RE: **Jomar/Martinez Residence**
2123 Candelaria NW
Grading Plan Stamp Date: 8/1/18
Hydrology File: G13D035

Based on the submittal received 8/1/18, the Grading Plan cannot be approved for Plat or Grading Permit until the following are corrected:

ENGINEER'S SEAL	2123 CANDELARIA RD JOMAR CANDELARIA RESIDENCE	DRAWN BY DEM
	GRADING AND DRAINAGE PLAN	DATE 7-31-18
8/23/18 8/1/18	 1608 CENTRAL AVENUE SE SUITE 201 ALBUQUERQUE, NM 87106 (505) 972-0899	JAMAR CANDELARIA G&D
DAVID SOULE P.E. #14522		SHEET # C1
		JOB #

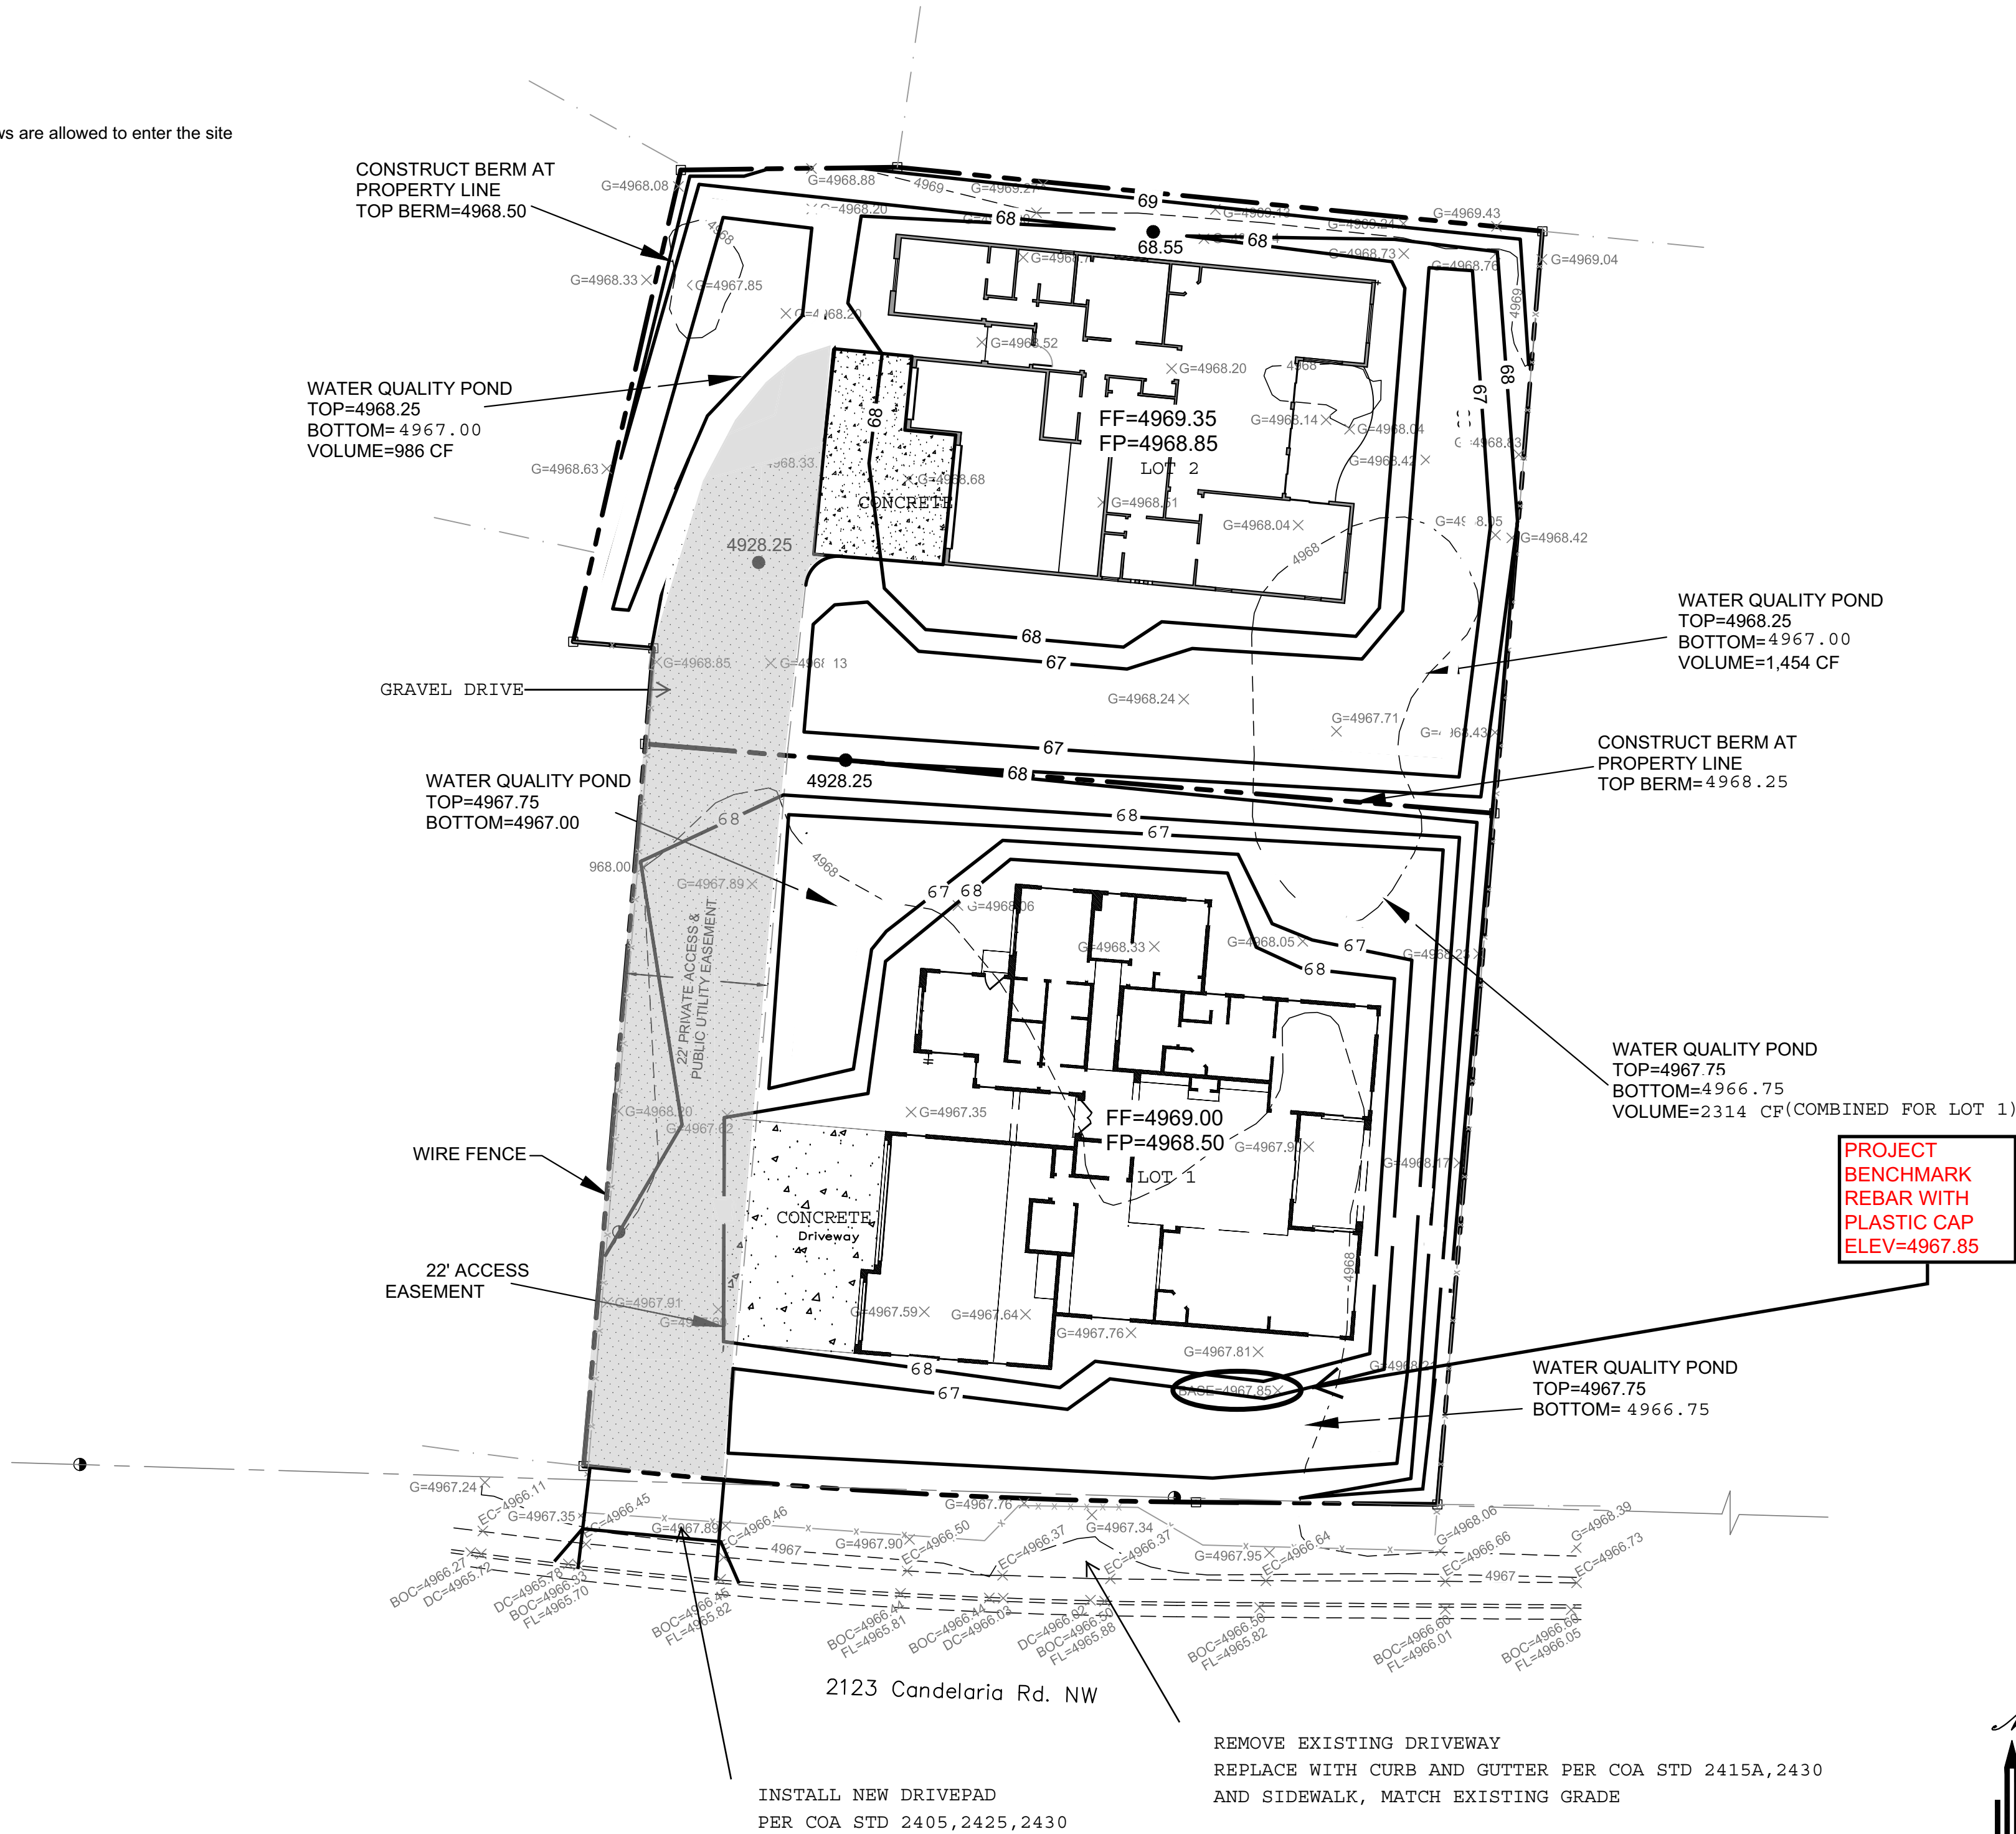
1. Include project benchmark.
2. Provide topographic survey for the adjoining properties (~10' across the property line); ensure your proposed grades tie in at the property line.
3. Add note on the plan that "No work shall be performed in the public ROW without an approved Work Order or Excavation Permit."
4. On the Plat, provide a drainage easement over the ponds and annotate using the [Plat Drainage Easement Note](#). This note replaces the need for a separate drainage covenant.
